From: Bloomer, David <David.Bloomer@lancashire.gov.uk>
Sent: 25 August 2016 08:57
To: Adam Birkett
Cc: LHS Customer Service; planning
Subject: app3/2016/0627 Ford House Alston Lane

| Drawing title | PROPOSED BLOCK PLAN | | |

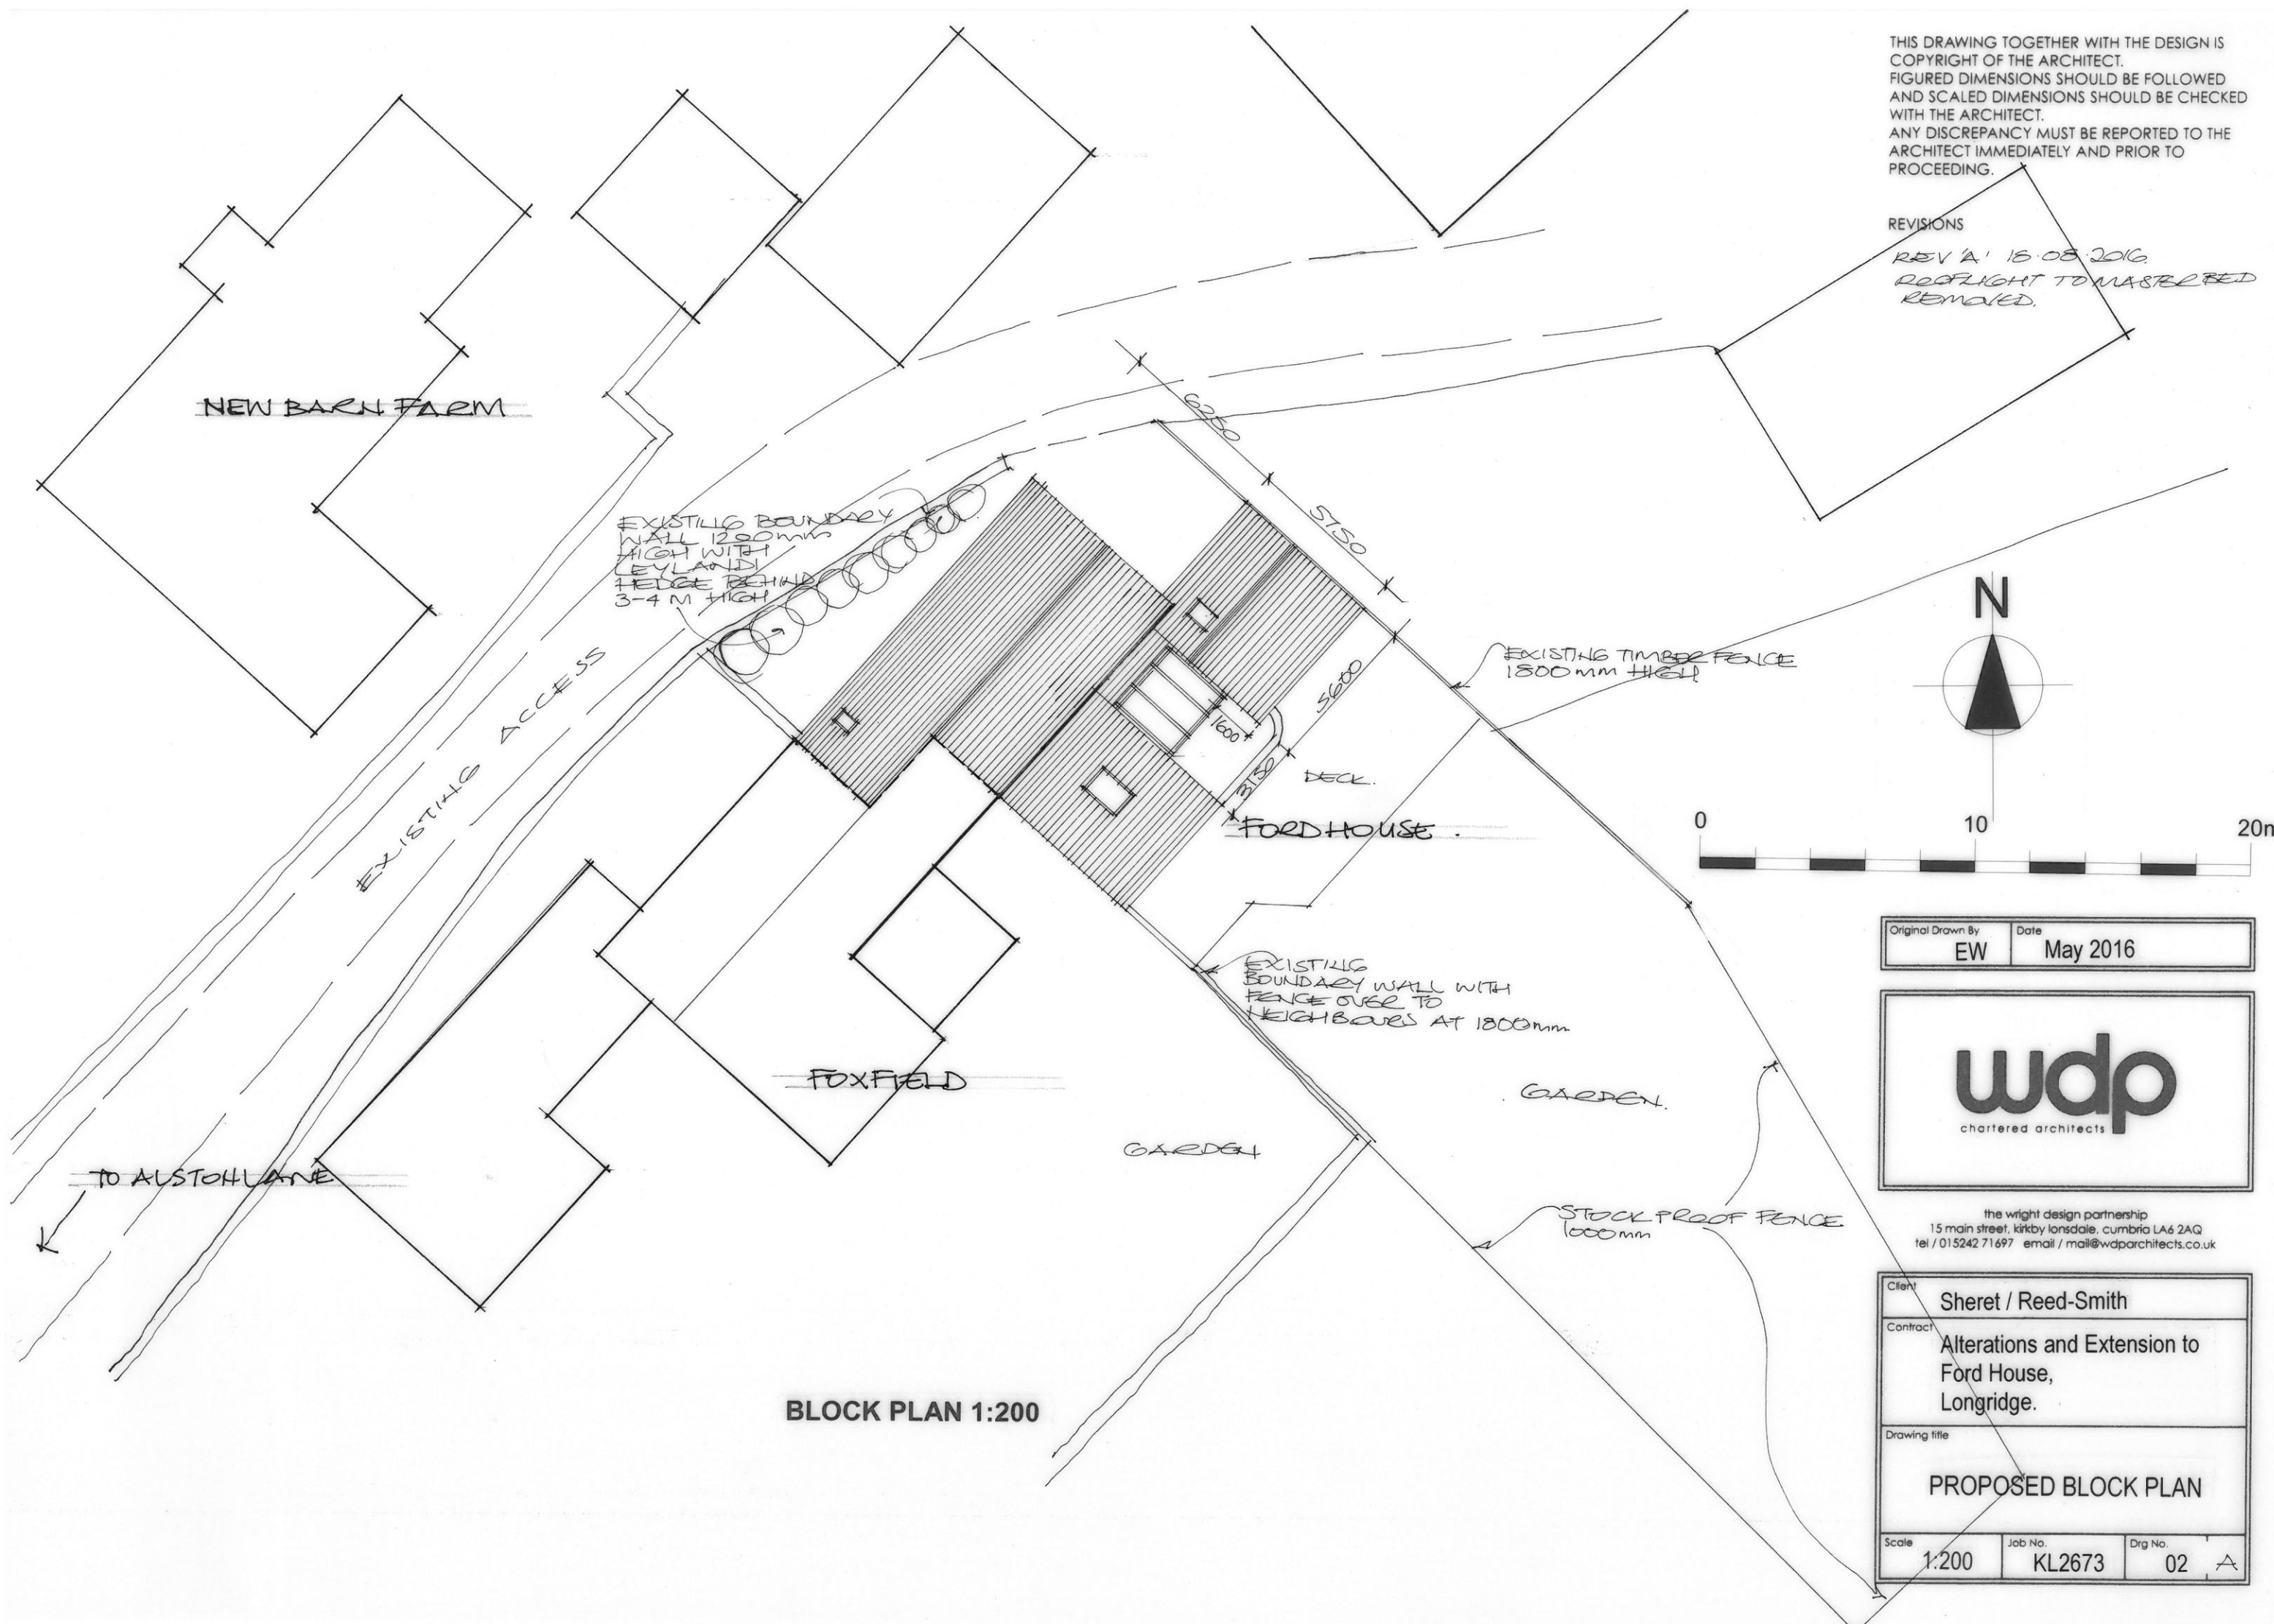
The proposed extension encroaches onto the existing parking space leaving only 1 usable parking space for the development which would not be acceptable as it would lead to additional parking on the lane which whilst not adopted highway would inconvenience the other residents of the lane and compromise the safety of pedestrians ((the lane is a public right of way Footpath 90) I would there're recommend that the application be refused on the grounds of inadequate parking provision which would compromise the safety and convenience of the users of the lane
